# **Vattenfall Wind Power Ltd**

## **Thanet Extension Offshore Wind Farm**

Appendix 7 to Deadline 8 Submission: Response to  
Deadline 7 submissions on Fish Ecology

Date: June 2019

Figure 4-3 Contour plot showing the modelled unweighted SPL_{peak} values for installing a monopile using a maximum blow energy of 5000 kJ at the East modelling location

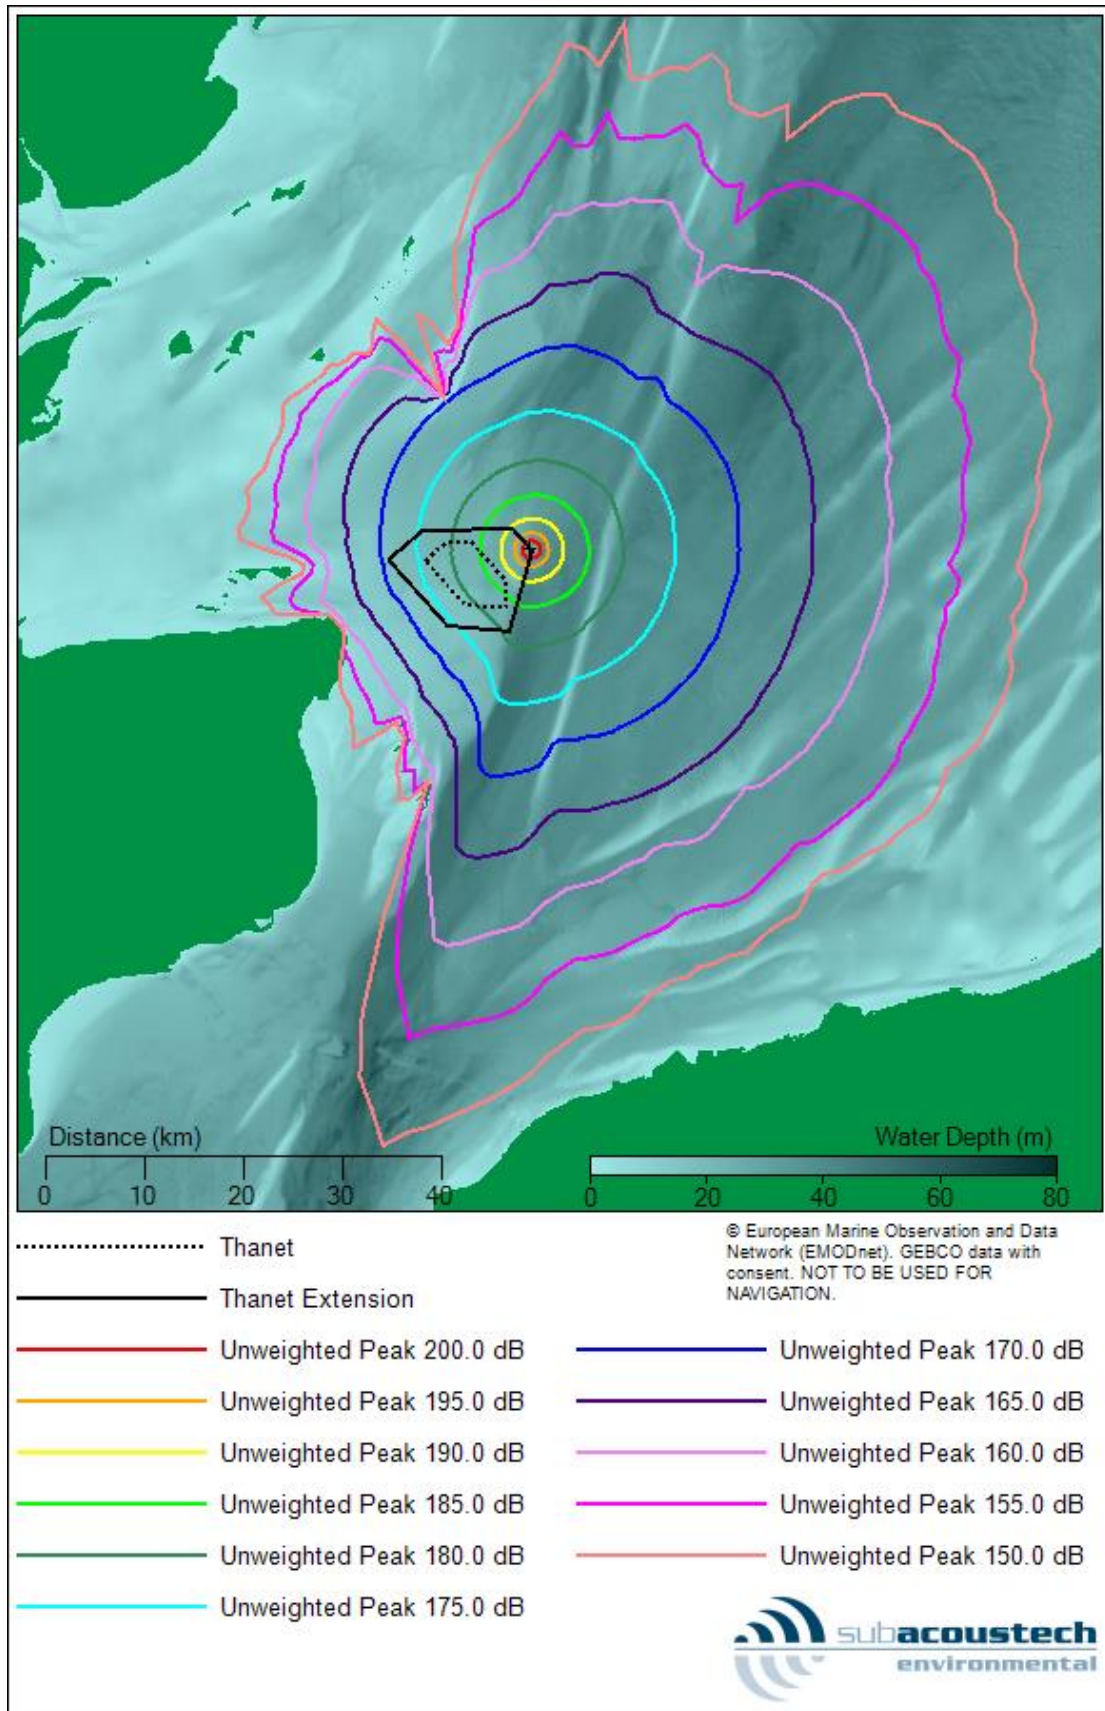
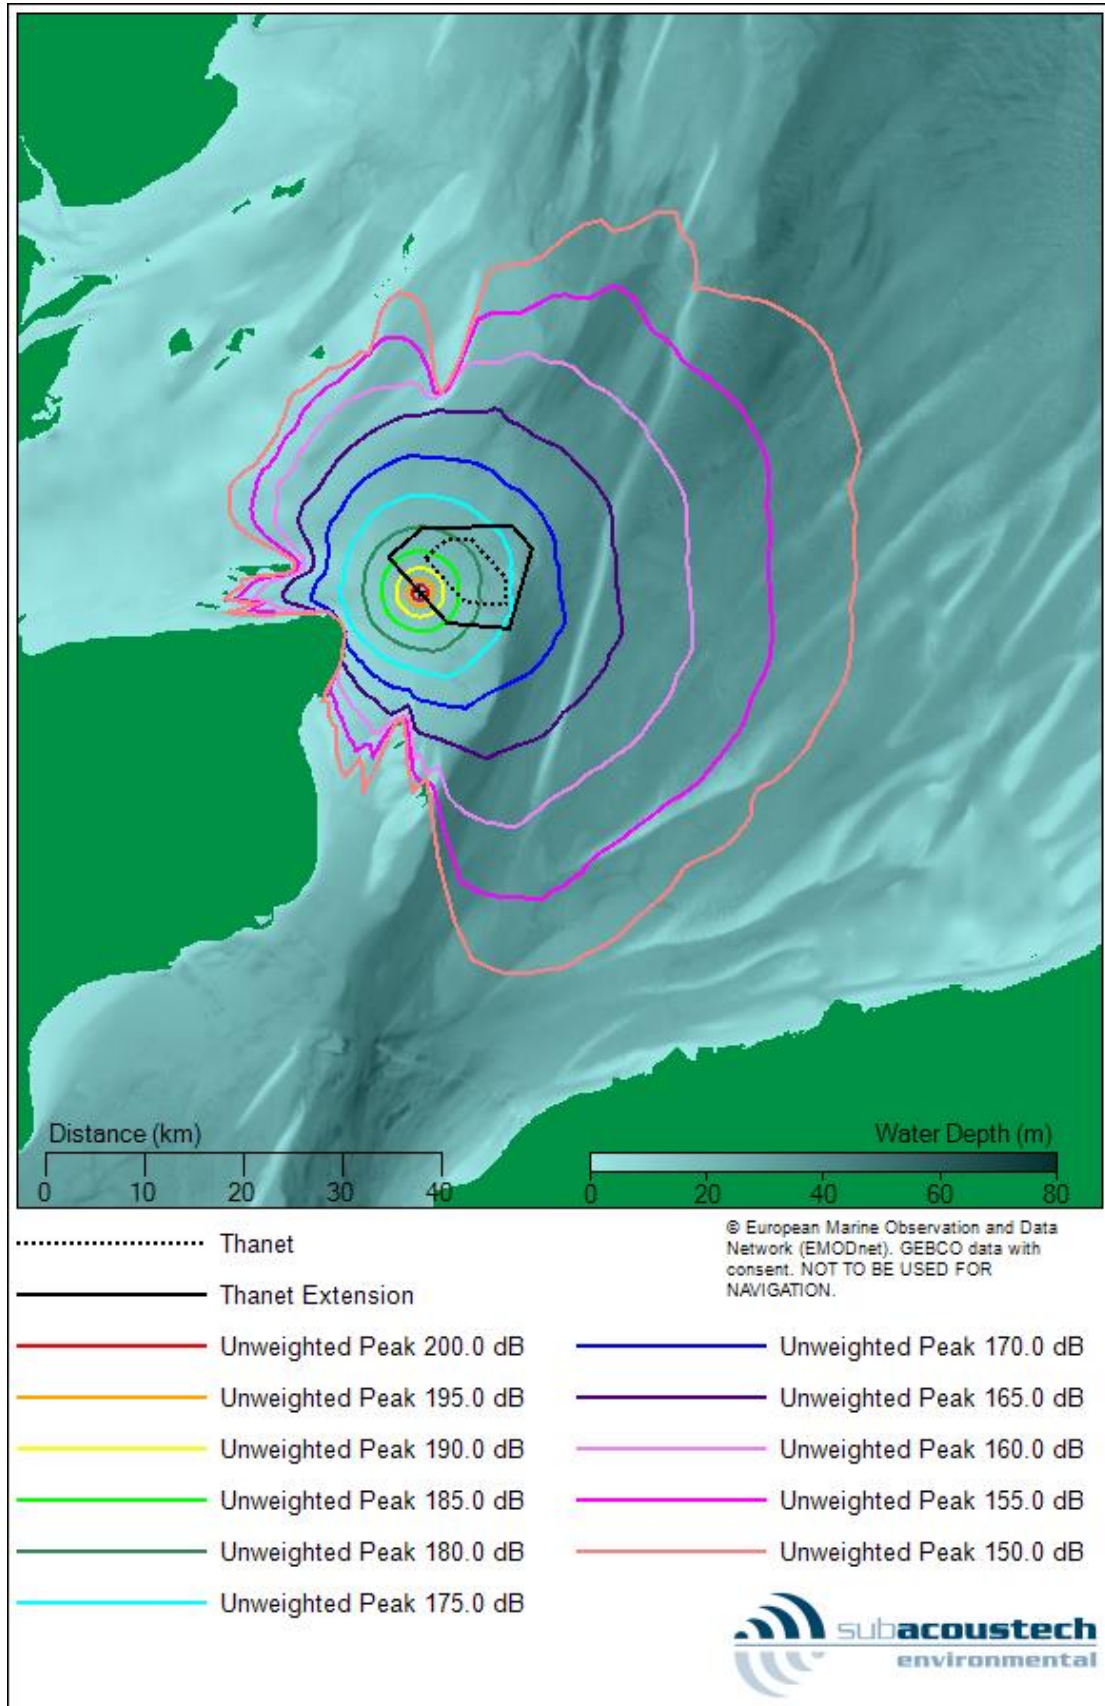
MMO D7 position	Applicant D8 Position
<p>ersonified is greater.</p> <p>The Applicant is correct in that the peak SPL is more precautionary than the SELs in this case due to the way this metric is modelled. The MMO acknowledge that the Applicant has provided the peak SPL contours in Annex 6-3 Underwater Noise Assessment (APP-086). This assessment was previously reviewed as part of the MMO’s consultation on the Environmental Statement and nonetheless concerns were raised at the time with respect to behavioural impacts Figures 4-3 (Appendix A) and 4-4 of Annex 6-3 show contour plots for the modelled unweighted SPLpeak values for installing a monopile using a hammer energy of 5,000 kJ, for the East and South West locations respectively. Figures 4-5 and 4-6 show the SPLpeak contours for installing pin piles with the lower hammer energy of 2,700 kJ. However, these maps should show the spawning grounds/International Herring Larvae Survey (IHLS) data, so it is clear what noise levels spawning herring are predicted to be exposed to.</p> <p>Secondly, the Applicant has advised that the SELs metric was not remodelled (as requested) as part of the post application phase but was included in Annex 6-3 in addition to SPLpeak. “The SELs contours are shown in page 37 et seq of the report and demonstrate clearly that there is no effect receptor pathway between the proposed project and the Thames stock....I trust this addresses the behavioural concerns with regards the Thames stock west of the Margate Sands sandbank”.</p> <p>The MMO acknowledge that some figures showing SELs contours have been provided in Annex 6-3. However, the SELs contour plots the Applicant is referring to relate to various (and limited) SELs</p>	<p>The Applicant notes that this was agreed under the auspices of the EIA Evidence Plan (App Ref 8.5) with explicit reference made to agreement being reached on “Fish ecology baseline characterisation and assessment scope”. The Applicant welcomes confirmation provided in the MMO’s D6 submission that the change in policy reflects an apparent concern over other developer submissions rather than anything based within the scientific literature that would drive a change in policy. The Applicant maintains its disappointment that matters agreed under the evidence plan have resulted in significant discussion due to a change in approach that is seemingly not underpinned by science but rather approaches taken on other developments.</p> <p>Notwithstanding this the Applicant provided the cross references to demonstrate that the SELs and SPL had both been modelled as requested. At this late stage in the examination the Applicant is surprised to have a request asking for illustrations of isopleths that have no relevance in the literature, in order to understand a potential effect on fish behaviour against an undefined metric for which there is limited scientific evidence.</p> <p>The Applicant can confirm that the SELs and SPLpeak metrics were not remodelled. This is because they were provided with the application. The illustrations referred to reflect unweighted thresholds, which were requested for marine mammals by Natural England (with MMO present). Because the metrics are unweighted</p>

Figure A 5 Contour plot showing the impact ranges for harbour porpoise (Lucke et al., 2009) at the east location for installing a monopile with a maximum blow energy of 5000 kJ

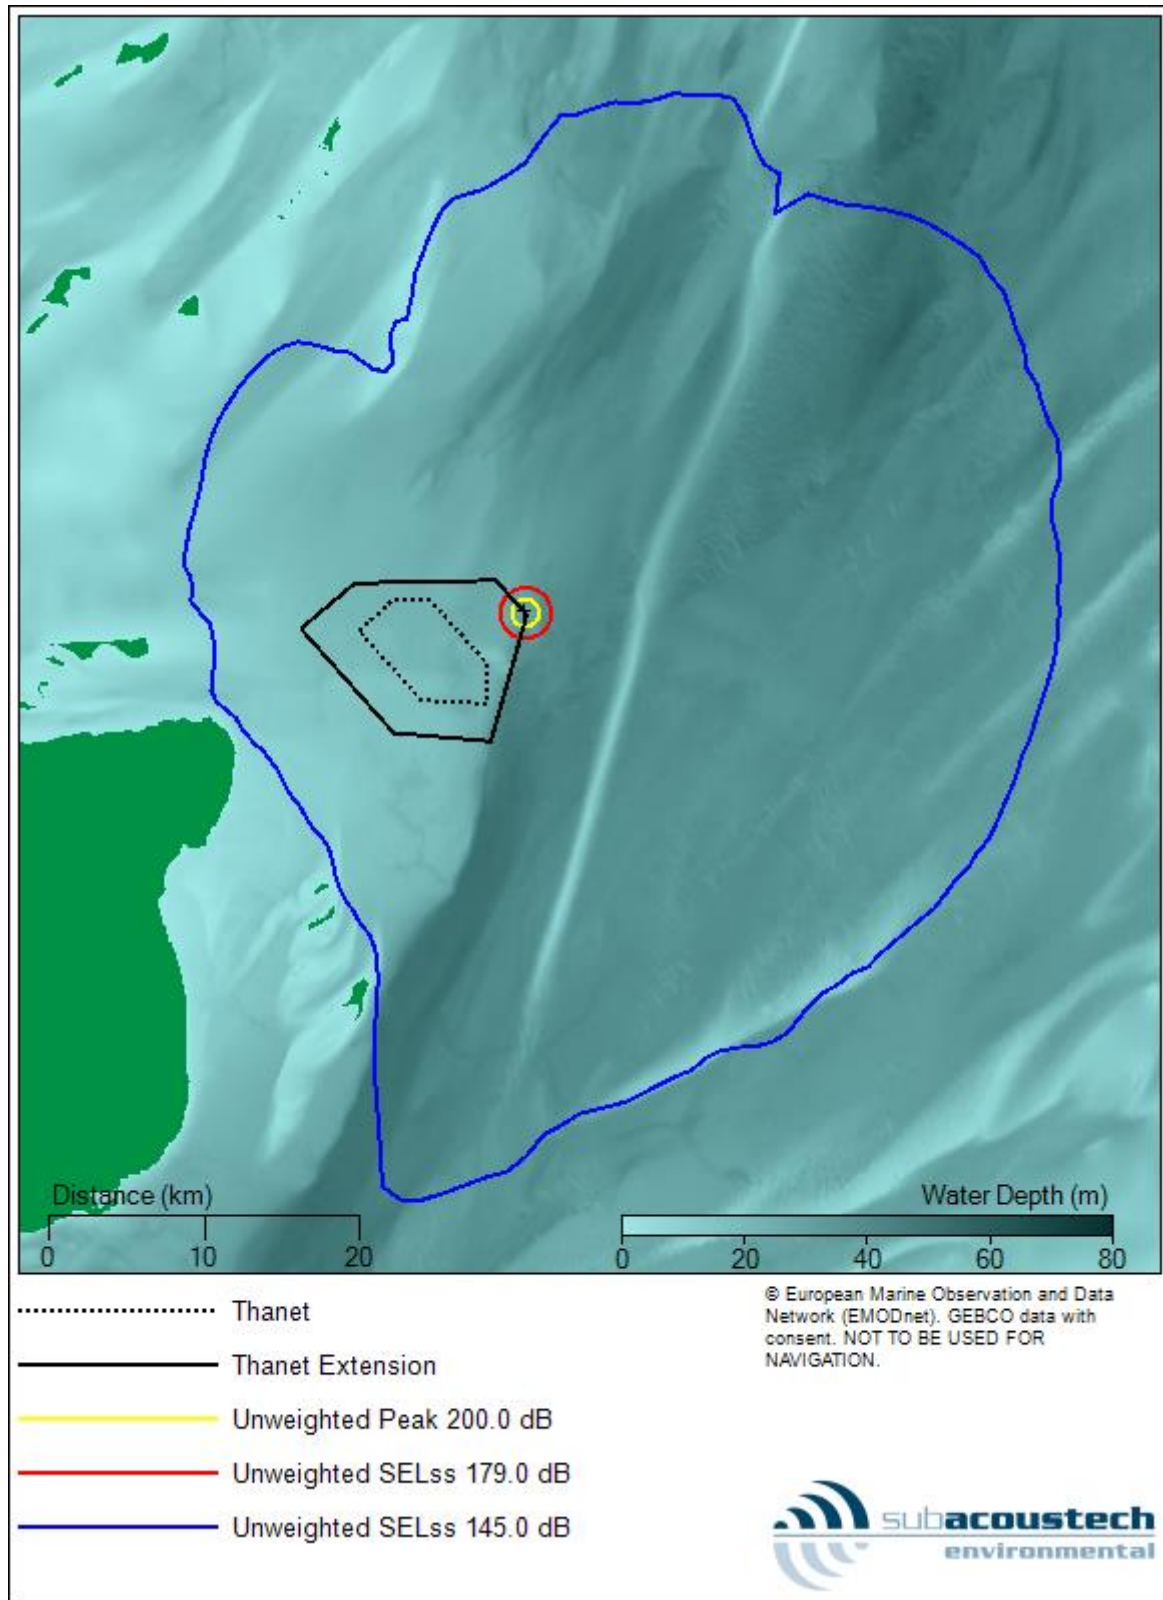
MMO D7 position	Applicant D8 Position
<p>thresholds based on marine mammal noise exposure criteria (i.e. see Figure A5 in Appendix A showing the 179 dB and 145 dB SELss contours). As above, the herring spawning grounds should be clearly shown. To fully assess impact the Applicant should provide a figure (similar to Figure 4-3) of the modelled incremental SELss isopleths/contours, which include the noise levels at the herring spawning grounds.</p>	<p>they apply generally, and are not weighted to particular marine mammal noise exposure criteria.</p> <p>The Applicant’s position is that incremental contours, whilst applicable to marine mammals, are simply not relevant for fish species in this context. The agreed noise criteria (Popper et al 2014, etc) agreed for fish are the best available evidence on which to base an assessment, and the Applicant is unclear why a range of isopleths are being requested at this late stage.</p>

<p>The Applicant questions what the merit of further SELss would be, and on what scientific evidence the request is made on. Should the MMO receive the appropriate information, it can determine whether a piling restriction is considered necessary for the Thames stock. Essentially, the MMO requires sight of either the modelled SPLpeak or SELss noise isopleths overlaid onto herring spawning grounds/appropriate IHLS data for the two modelled locations, in order to make an informed judgement on the potential risk of behavioural effects on spawning herring. Based on the evidence submitted by the Applicant to date, it is currently difficult to ascertain what the predicted noise levels will be at the spawning grounds. In the circumstances, the MMO must adopt a precautionary approach and maintain that the proposed restrictions are fully justified.</p>	<p>The Applicant considers there to be no appropriate evidence demonstrating that a behavioural effect would be experienced at the Thames spawning ground. The illustrations provided below clearly demonstrate that the Margate Sands complex forms a barrier to noise. For the avoidance of doubt the comparative figures below illustrate the historical herring grounds as defined by Coull et al (1998), and illustrated in the ES chapter, against the unweighted SPLpeak incremental contours. There is demonstrably no interaction and as such the Applicant considers any mitigation to be entirely unsupported.</p>
